Your Ref: LU/330/18/PL

RE :- Land South of Cornfield Close, Littlehampton BN17 6LD

Thank you for your correspondence of 27th November 2018, advising me of the 'Demolition of existing buildings & the erection of 77 residential homes with associated access, car parking, cycle parking, refuse/recycling storage, landscaping, earthworks & infrastructure' application for which you seek advice from a crime prevention viewpoint.

Drawing
Flat Block B
Proposed Elevations

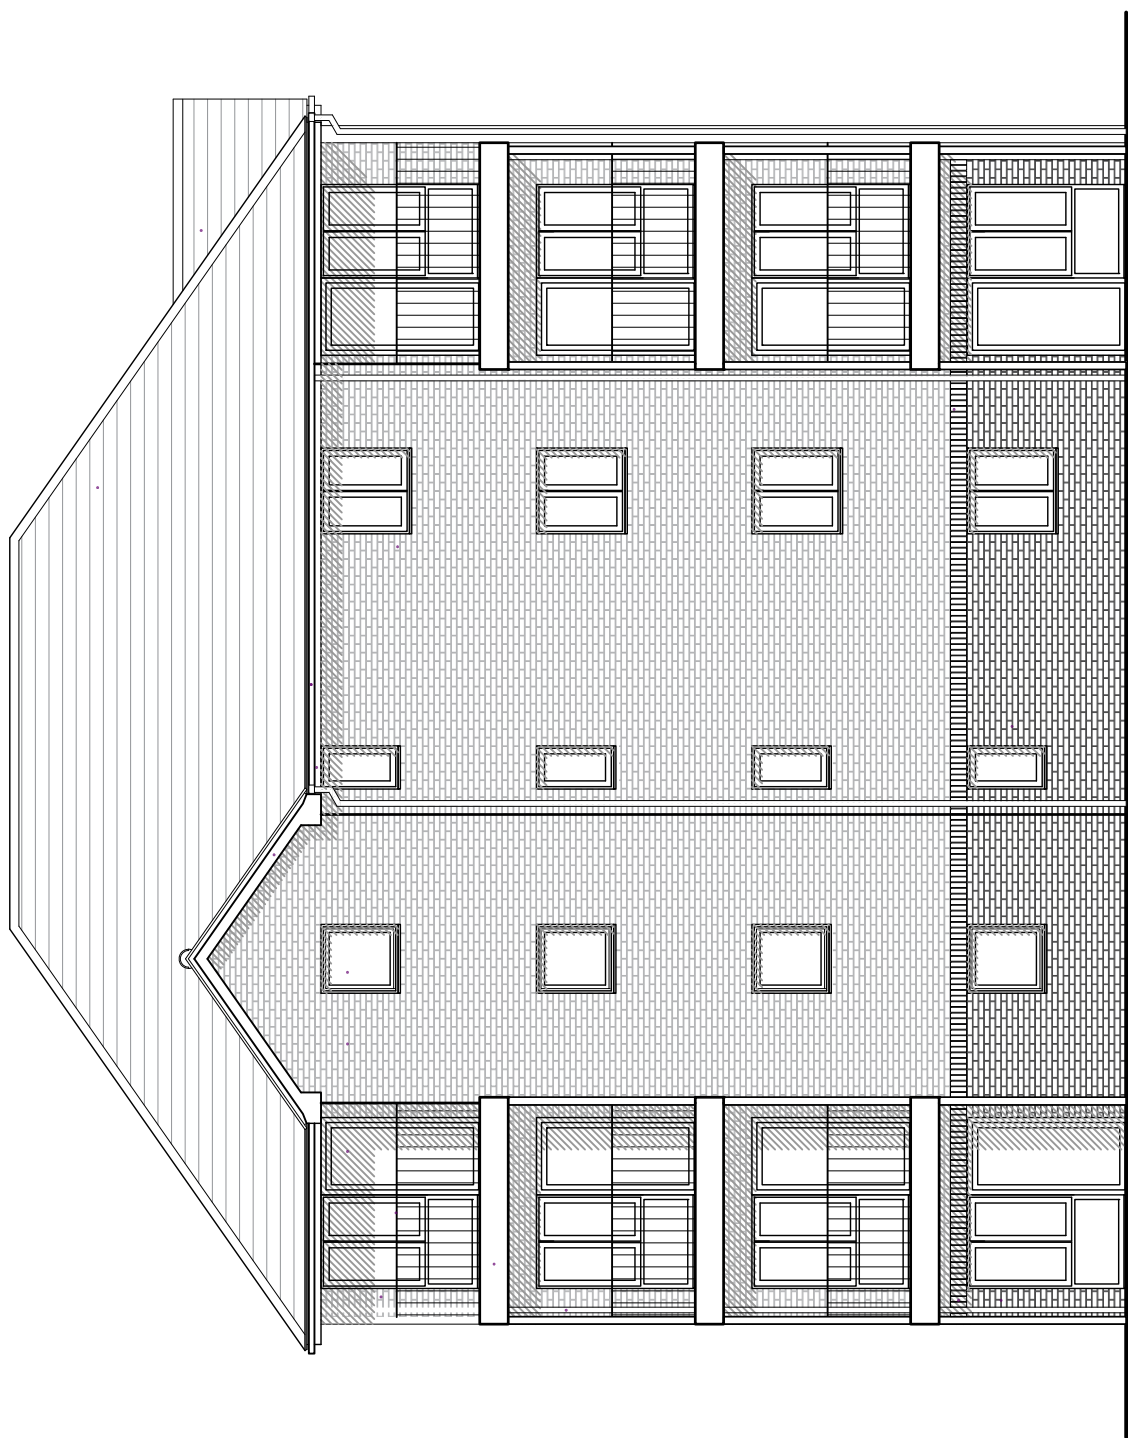
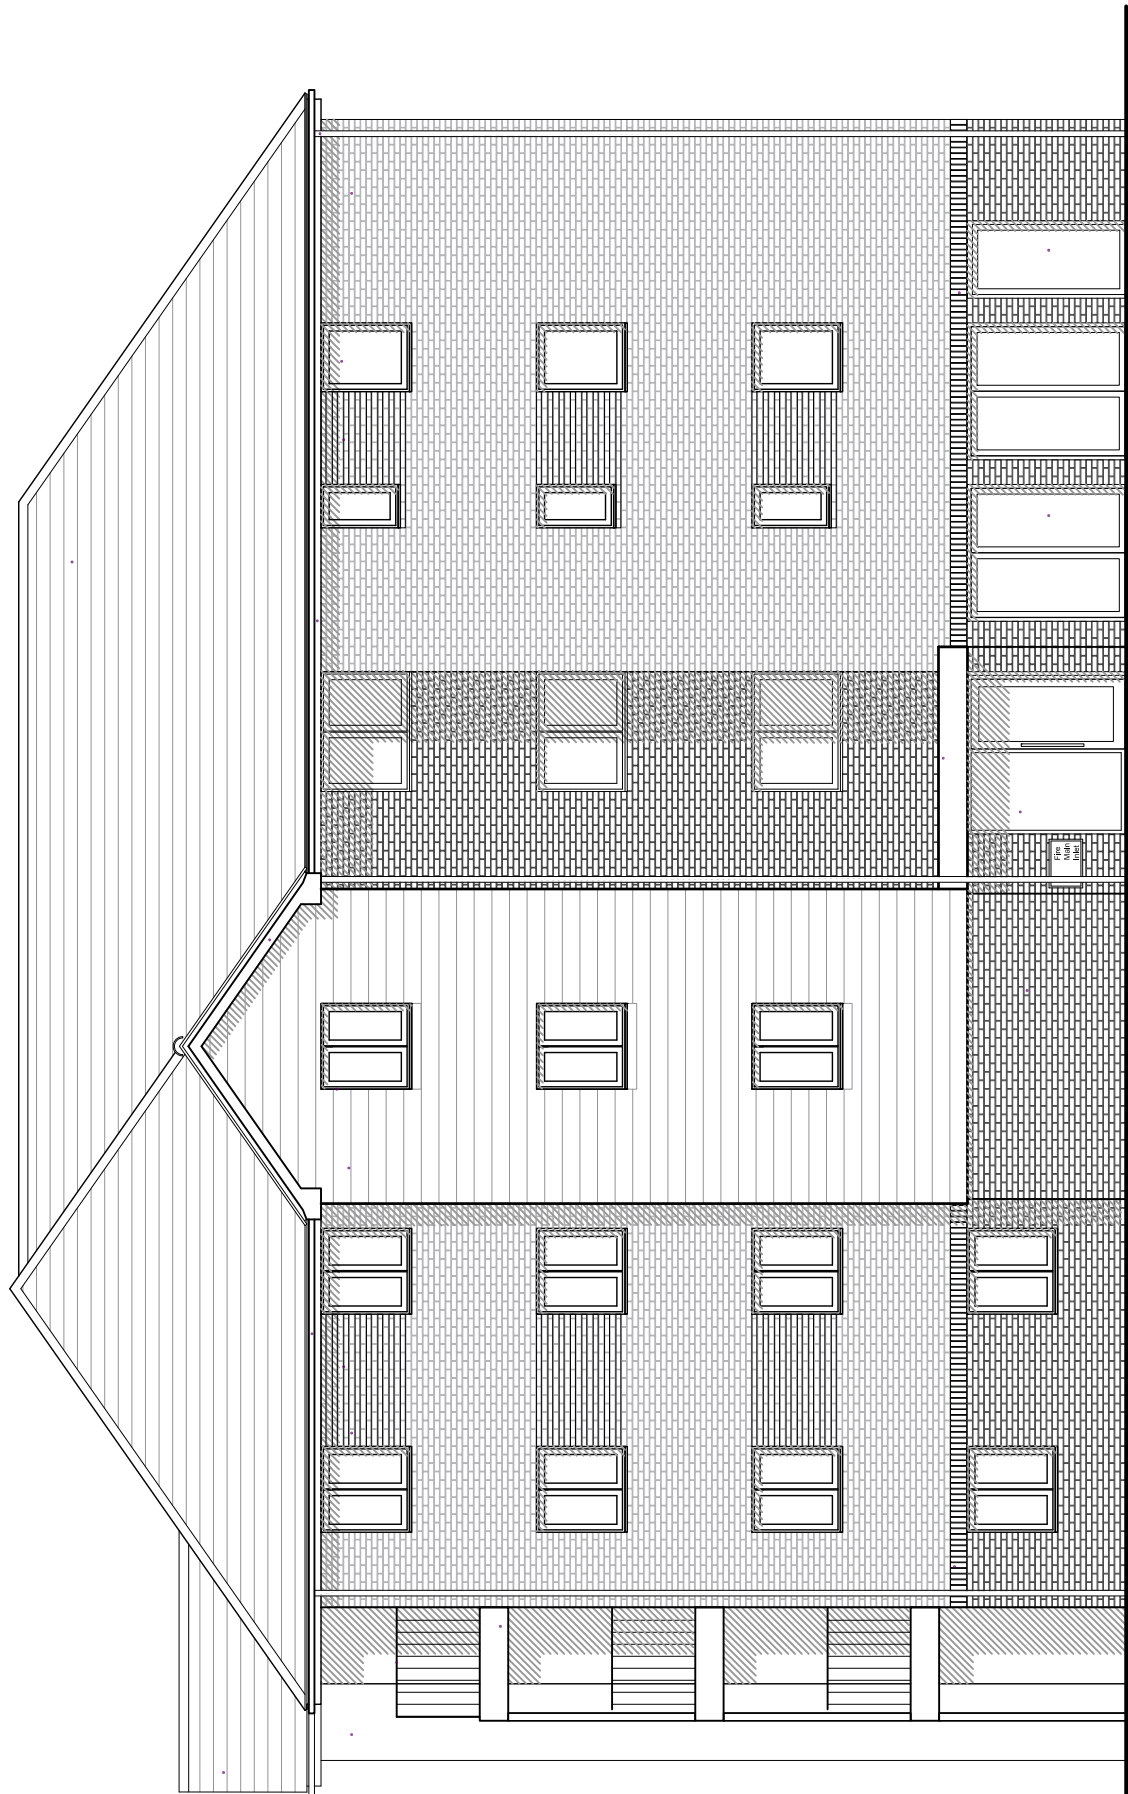
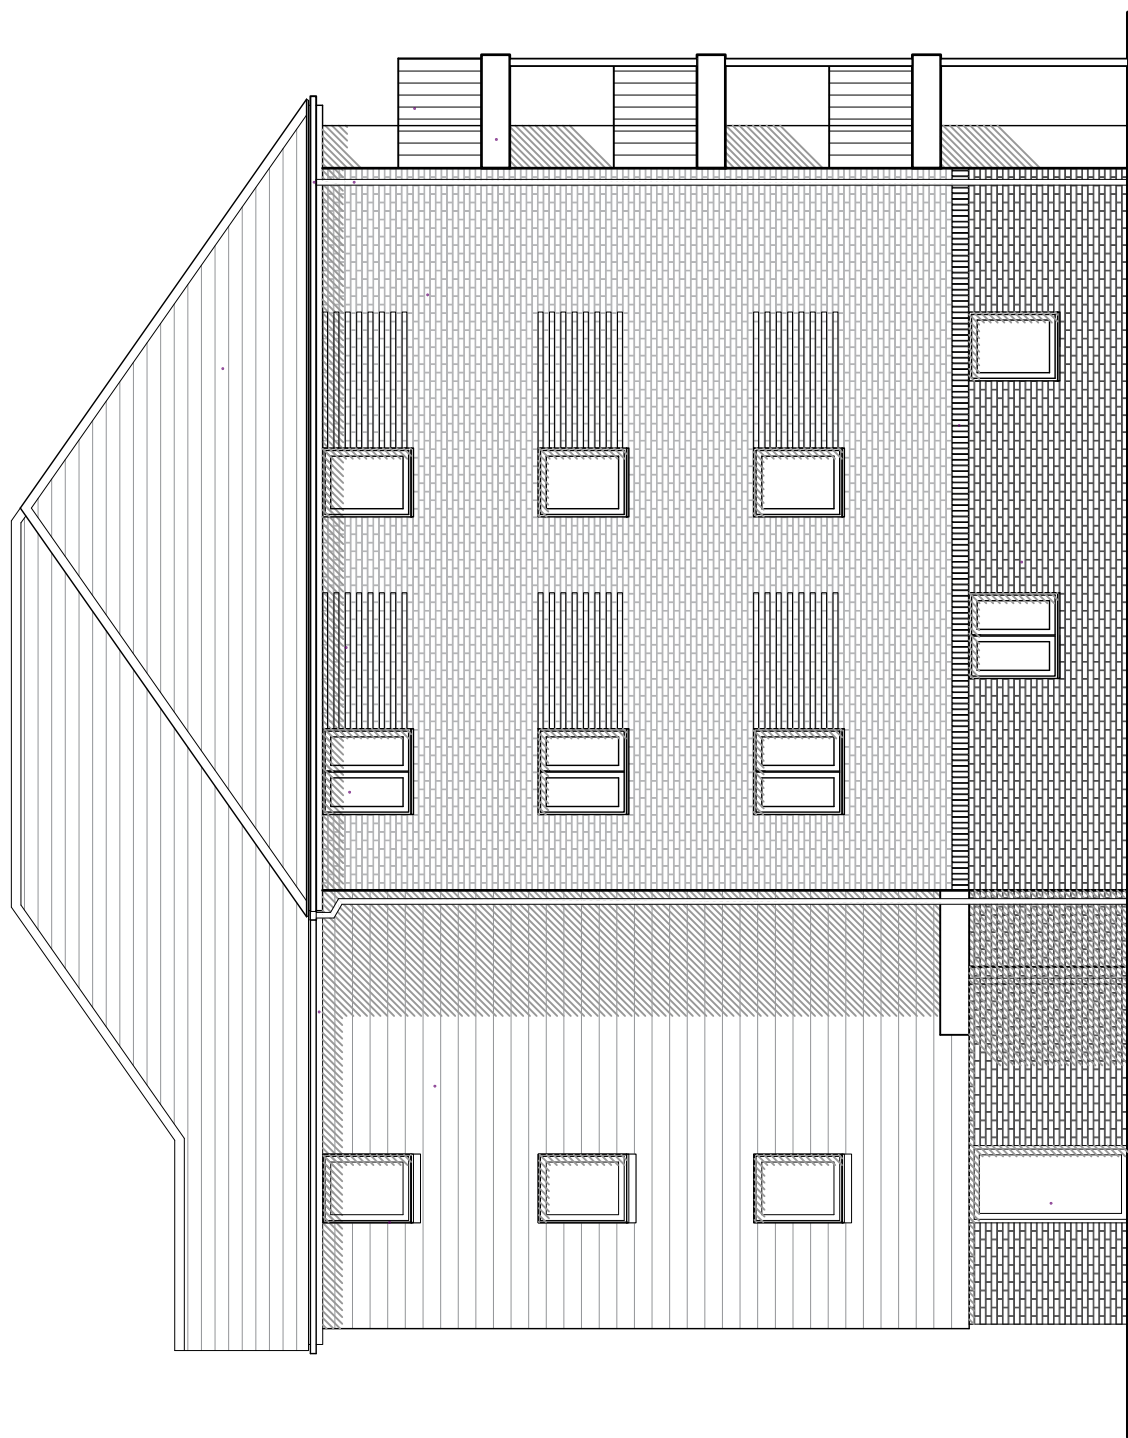
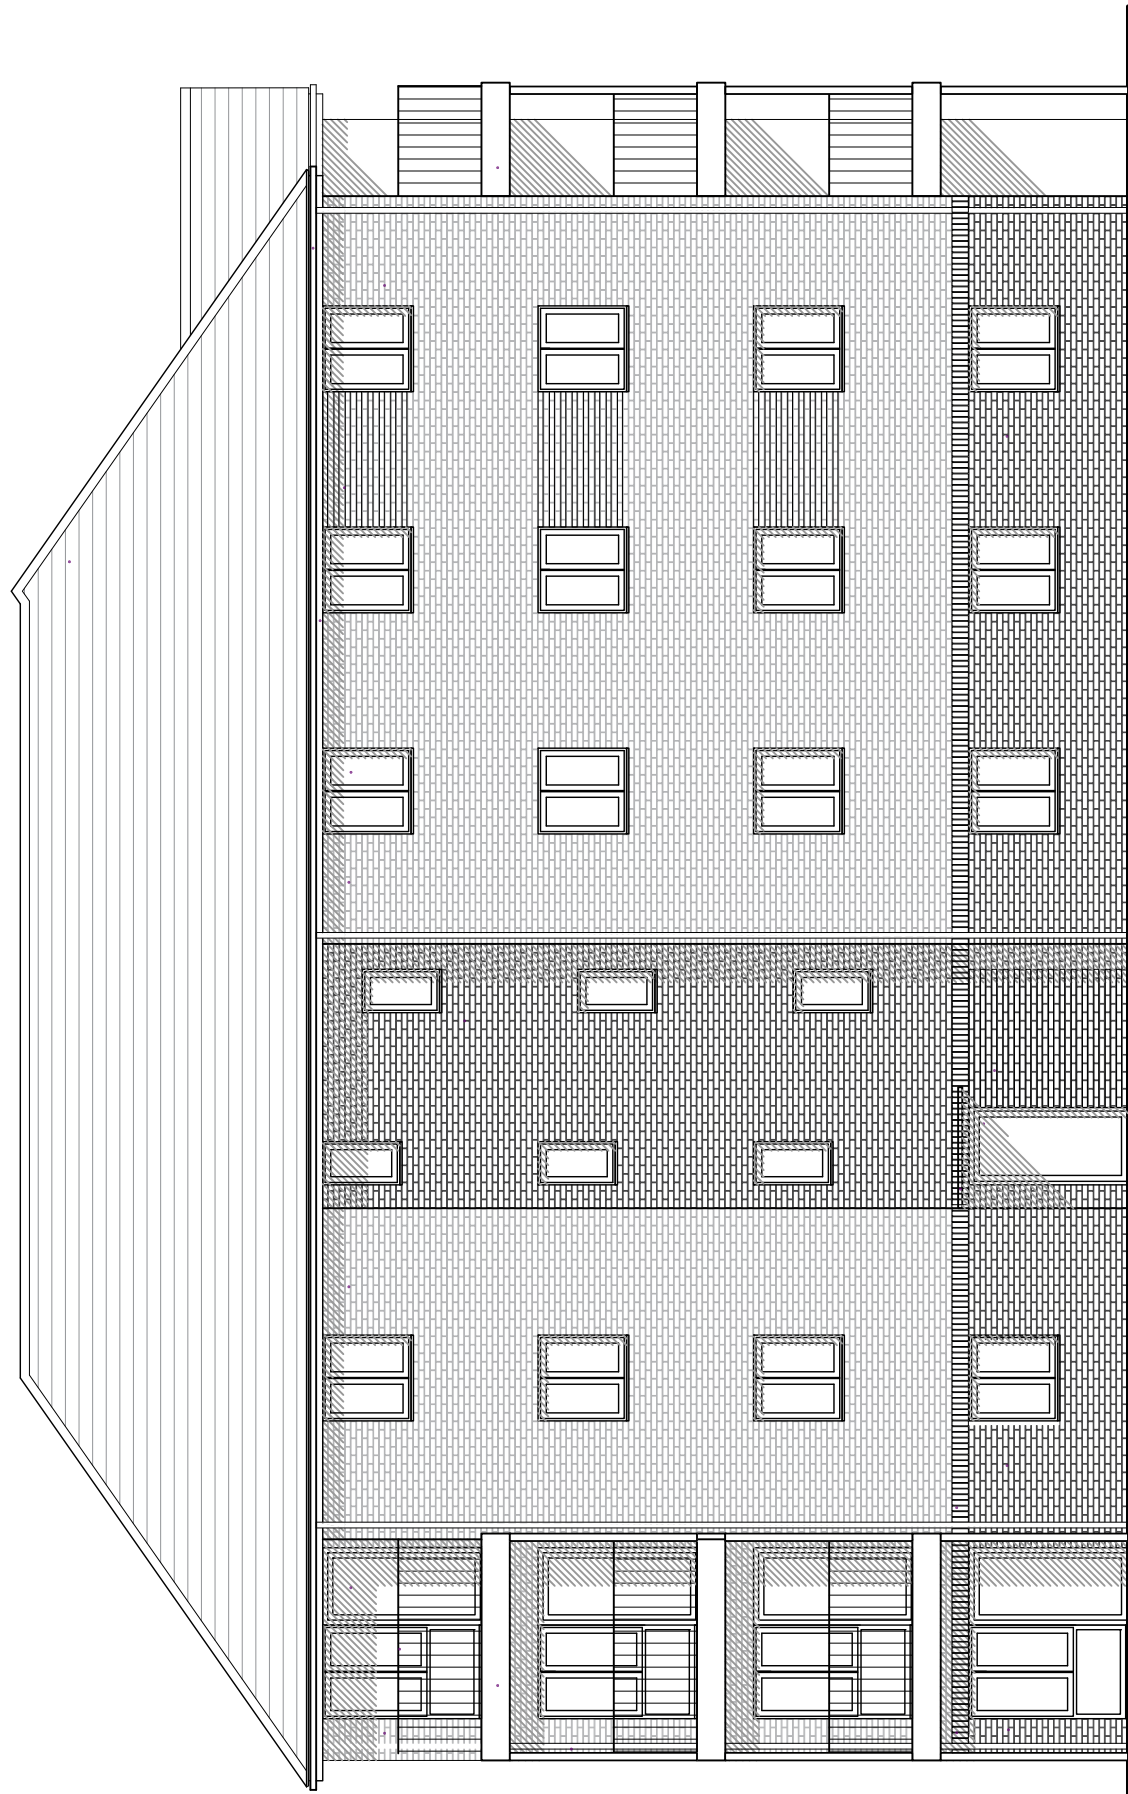
For an integral cycle store within the flats (block B) and with no access into the living accommodation and two double external doors. I would recommend no windows. I query whether two double doors are necessary and recommend a single certificated access controlled double door with internal thumb turn release to prevent accidental locking in. There should also be internal PIR activated lighting.

Should the two double outward opening doors remain, I recommend that a door closer is to be fitted along with spring loaded automatic shoot bolts to the unlocked door to ensure it closes first.

This arrangement would work very well for the refuse store double doors as well.

In relation to block B with twelve dwellings, from a crime prevention perspective, it will be imperative that access control is implemented into the design and layout to ensure control of entry is for authorised persons only. Chapter 27:7 of SBD Homes 2016 recommends that smaller developments containing up to 25 dwellings or bedrooms shall have a visitor door entry system. The technology by which the visitor door entry system operates is a matter of consumer choice, however it should provide the following attributes:

I would recommend window restrictors on the ground floor windows of block A and B that can be released internally in an emergency but can prevent the windows being opened fully from outside to allow unauthorised access.
